## Additional Written Representation at Deadline 5

### Proposed Sizewell Link Road – using good design to avoid adverse and foreseeable consequences

Plate 3.3. Proposed layout of SW1 crossing at Fordley Road. (Source: Extract from Book 6, Volume 6, Chapter 2, drawing SZC-SZ0204-XX-000-DRW-100057_P13 in the ES)

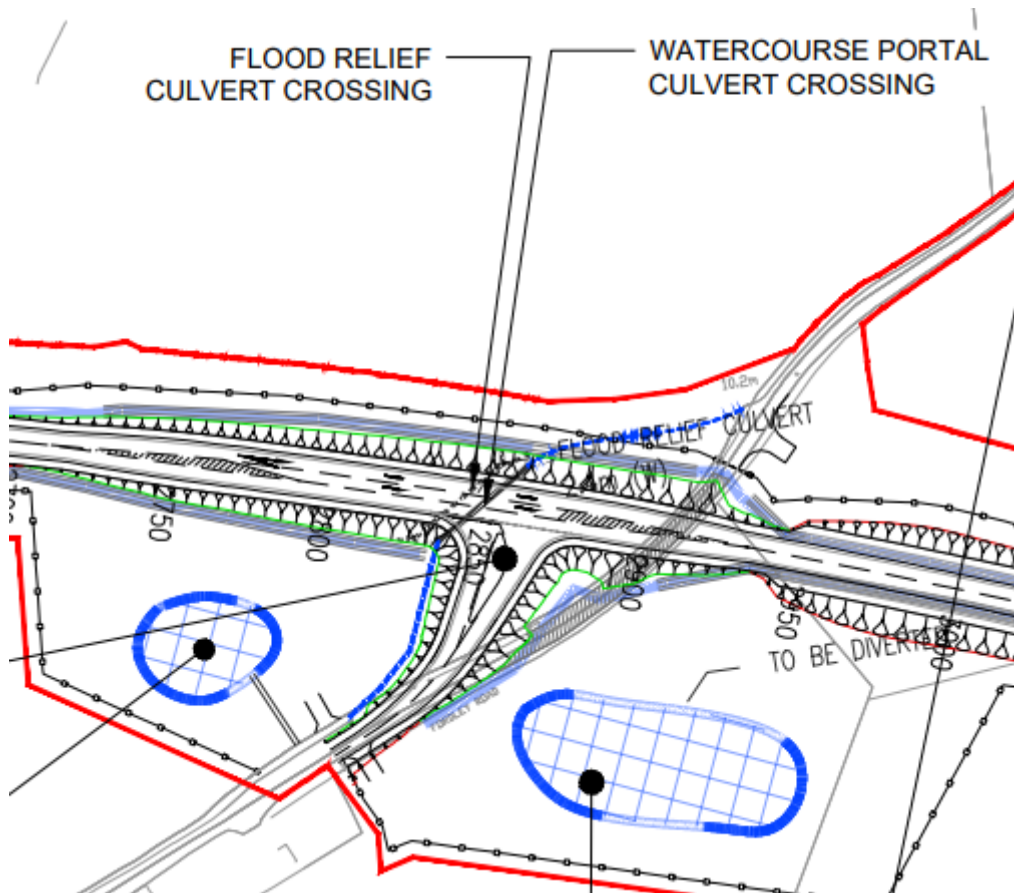
In the absence of the Design Brief for the proposed Sizewell Link Road being published, it is my contention that the Applicant has failed to meet the reasonable threshold for ‘good design’ in respect to the proposed junction of the SLR and Fordley Road.

Further, in the absence of any evidence to the contrary, it is my view that in designing this junction, the Applicant (or their agents) failed to fully consider (what are clearly foreseeable) consequences, for the communities of Fordley Road through to North Green, Tiggins Lane, Butchers Road, and into Kelsale-cum-Carlton itself.

Specifically, by making the footprint of the junction so much greater than the current B1122/Fordley Road junction, the design is altering the; entry/exit to a narrow single track road from one that is clearly that of a rural byway, into something that could be construed as a road suitable for all forms of motor vehicles.

It is evident to the local Parish Councils, residents, businesses and land-owners that unfettered access to the 'Quiet Lane' network via the proposed SLR junction is both destructive to the purpose of the lanes and will invariably give rise to unwarranted 'rat running' during periods of normal operation of the A12 and the proposed SLR.

However, all parties are even more concerned that in the event of; an accident, temporary closure or prolonged issue on the A12 or the SLR, Fordley Road and the aforementioned network of 'Quiet Lanes' could become inundated with high volumes of traffic and vehicles for which the unpaved, narrow carriageway are eminently unsuitable.
